From: Sarah Burrow <Sarah.Burrow@arun.gov.uk>
Sent: 20 May 2020 08:01
To: Planning.Responses <Planning.Responses@arun.gov.uk>
Cc: David Spring <David.Spring@arun.gov.uk>
Subject: RE: Please find attached amendment on planning application Ref: P/116/19/OUT

NOTIFICATION FROM ARUN DISTRICT COUNCIL
TOWN AND COUNTRY PLANNING ACT 1990
APPLICATION NO: P/116/19/OUT

Registered: 16-JAN-20
Site Address: Land adjacent to Sefter School House Sefter Road Bognor Regis
PO21 3EE

Description of Works: Outline application with all matters reserved, except for access, for the erection of 4 No. semi-detached 3-bedroom houses & 2 No. detached 4- bedroom houses with associated access, parking & gardens. This application is a Departure from the Development Plan.

Architect's Proposed Site Layout Plan

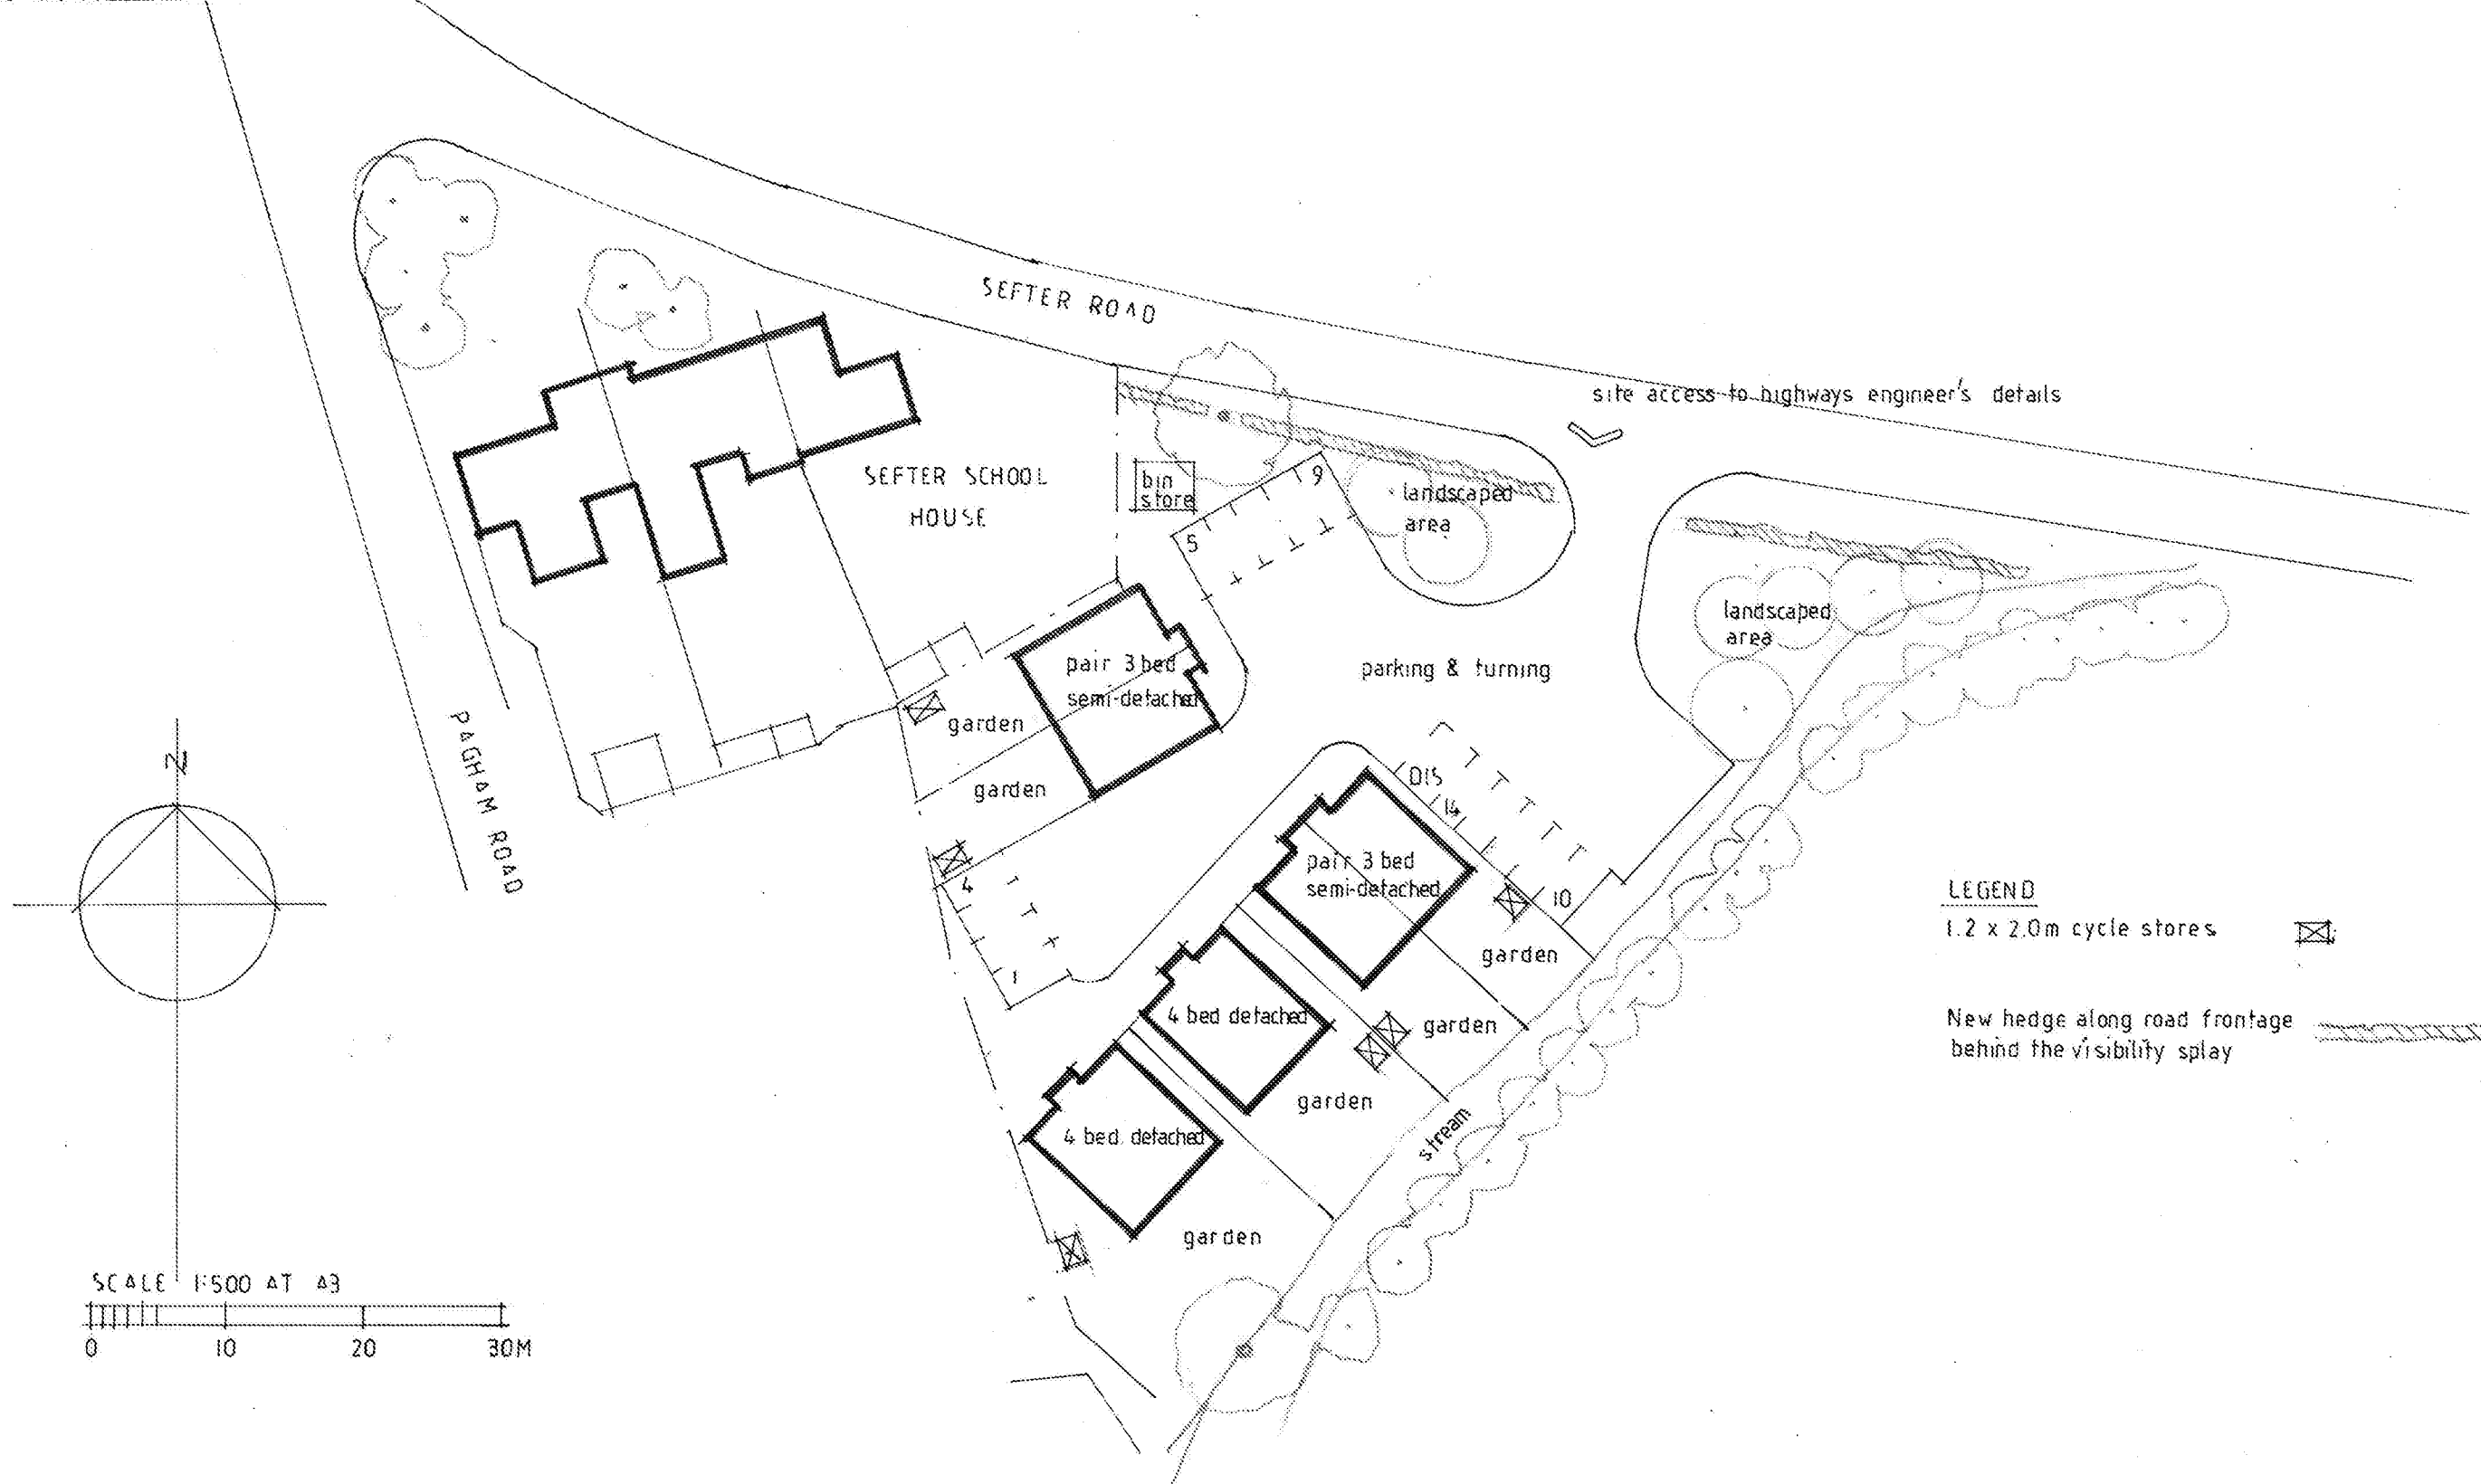
The updated plans are noted, the only concern raised by Engineers is that the boundary fences may be within 3m of the top banks of the watercourse. A 3m easement must be maintained for maintenance. It may well be that this is achieved, but it is unclear from the plans.
